From: Shaun Kneeland [REDACTED]
Sent: 27 September 2021 16:44
To: Kathryn Welch
Subject: Fwd: For the attention of Kathryn Welch
Attachments: House view between 43 & 45 Torton Hill.JPG; Side driveway.jpg

Reference AB/101/21/HH – 43 Torton Hill Road

LOCATION PLAN - SCALE 1:1250

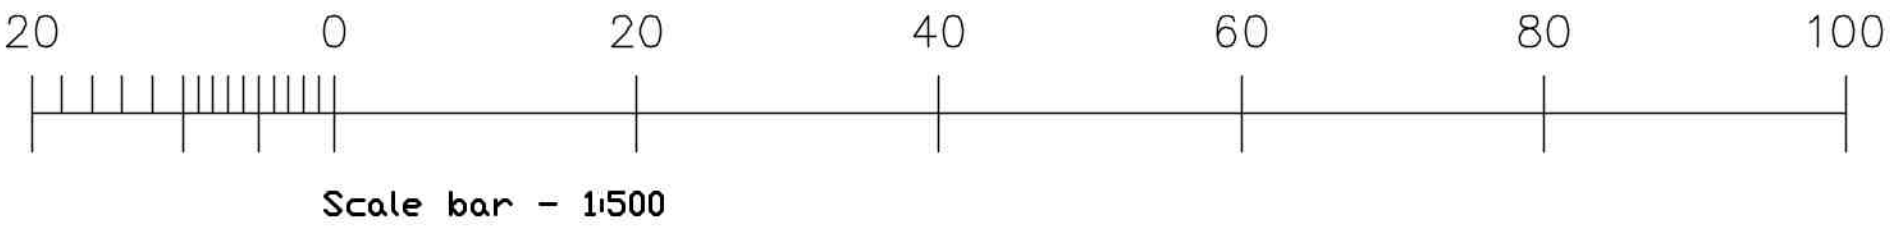
Thank you for your call today. Further to our conservation please find attached a couple pictures which show that the two houses 43 & 45 Torton Hill are divided on the side boundary by a party wall. Number 45 extends back the full length of this party wall. This was taken from the driveway on number 45 looking down from the front of the house. Please do let me know if you require anything further.

I understand you are the Planning Officer overseeing the above planning application. I have a query with regards to the location plan map attached, submitted as part of the planning application. Please find attached a copy of the scanned document. It appears this plan shows the outline for the homes on either side of 43 Torton Hill as they would have appeared in the original 1950's view and the homes on either side were extended in the early 2000's. Therefore, this location map is incorrect and misleading. The current location plan today is drastically different to the one attached. I hope this is just an oversight, however, I felt this was important to bring to your attention.

Will this document be important in the planning process if required to evaluate the impact of this extension (i.e. windows) for neighboring properties?
